Subject: AW/45/18/HH

Following consultation with the Conservation Officer I now need to request the following alterations to the appearance of the developemtn within the street scene (its front elevation);

sheet 3 of 5

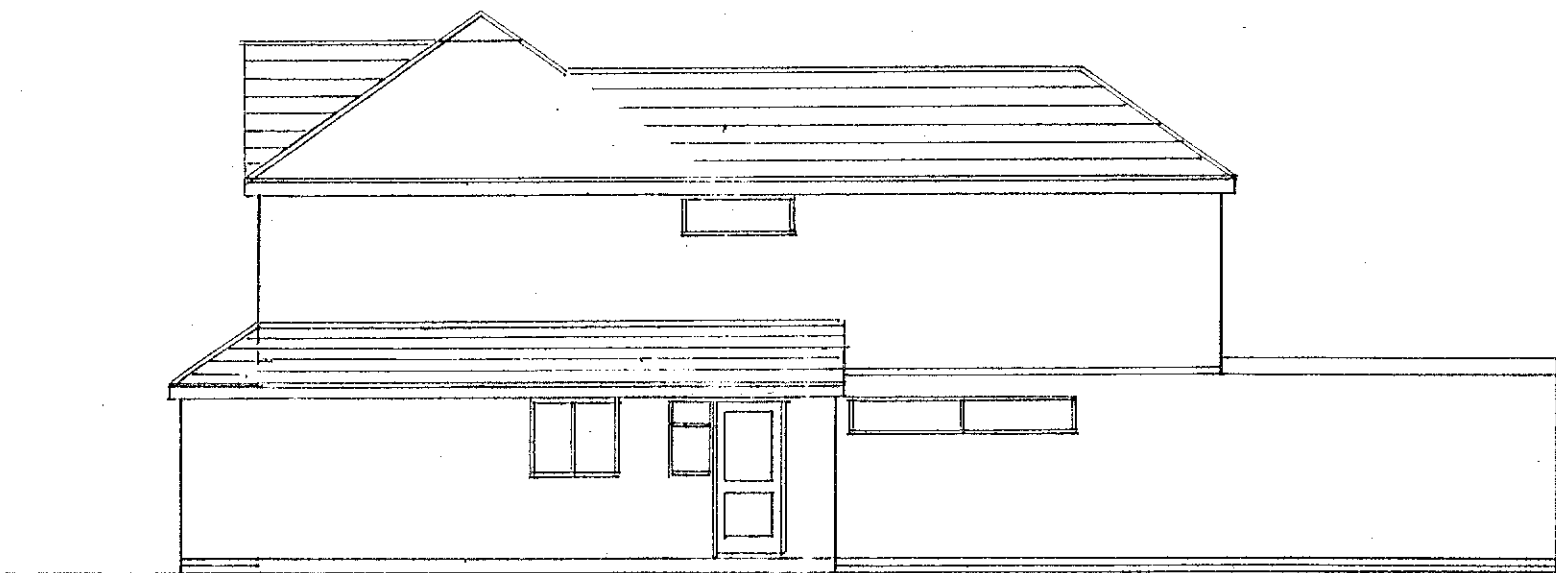
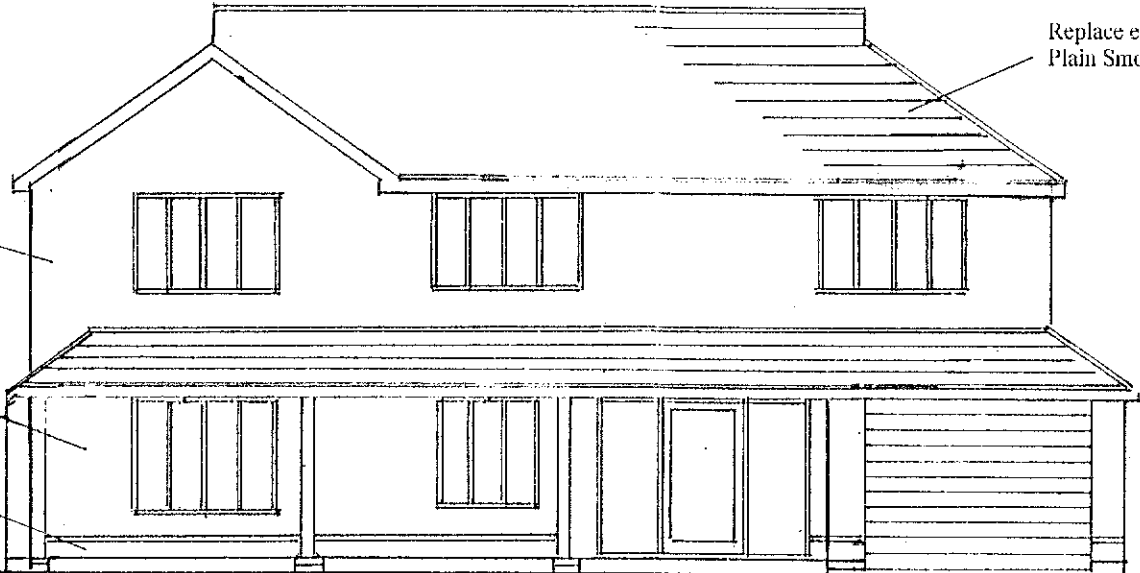
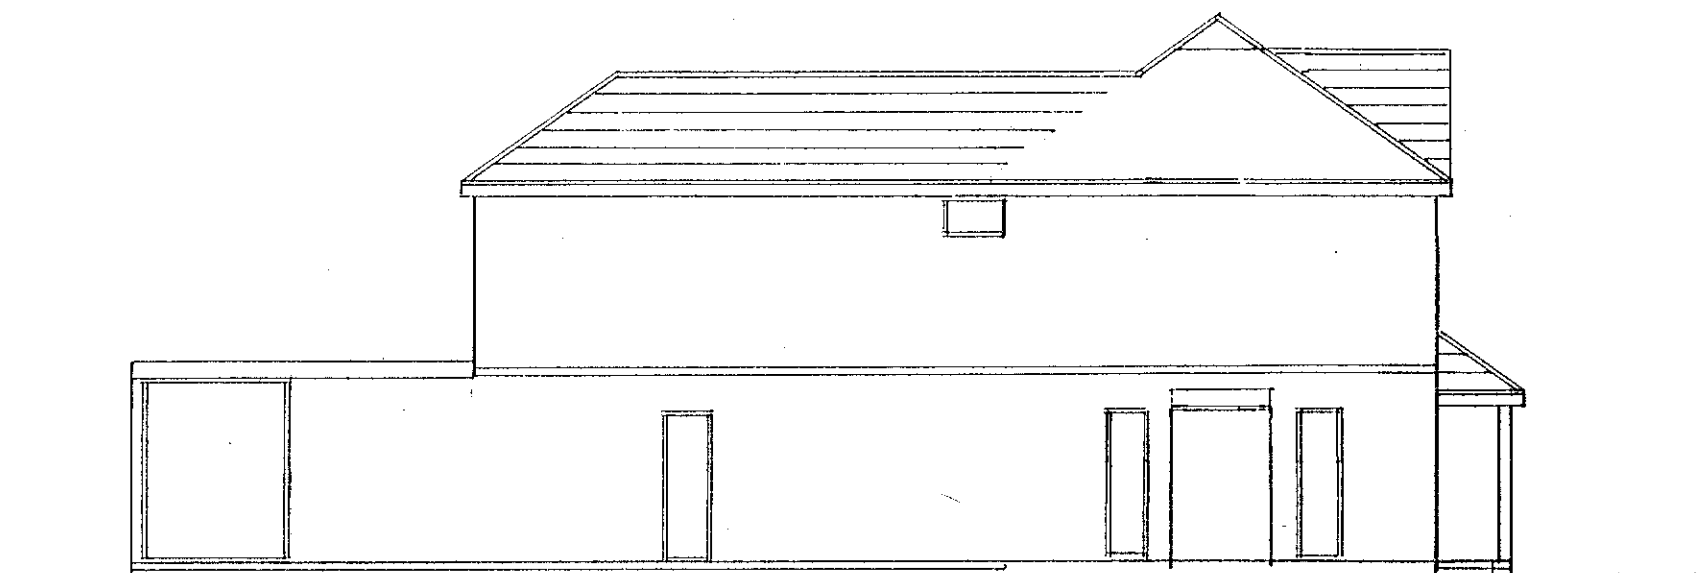
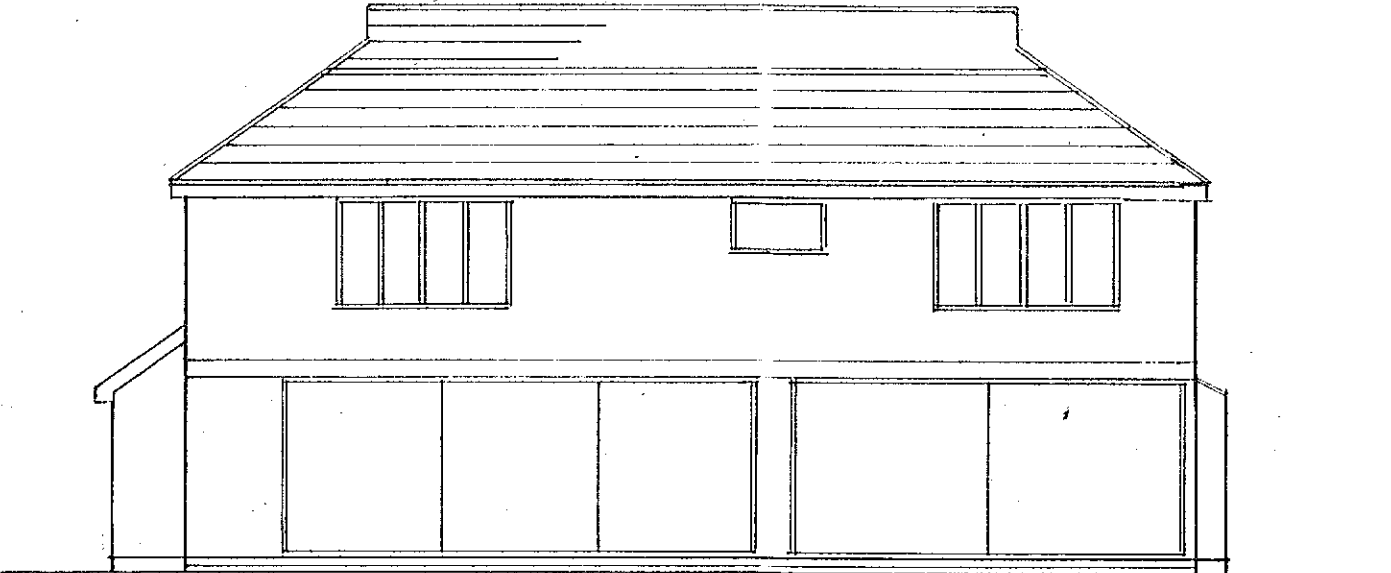
- 1) 19 Kingsway is a red brick and clay tile building. It would be ideal if the materials were red brick and clay tiles to match.
- 2) The window and door designs throughout the whole house proposed are at odds to the existing dwelling and to the dwelling at 21 Kingsway which is an important design lead in that it is a designated building of local character. Ideally it wold be wooden/aluminium framed cottage style windows as existing.
- 3) The veranda roof at ground floor needs to be removed from the scheme.
- 4) The pitched roof at the front on the west side needs to be removed.

Ideally the roof would reflect the existing roof in that it would be constructed of clay tiles , of the same roof pitch and with the same ridge features as the existing roof. Just wider to include the two storey side extension.
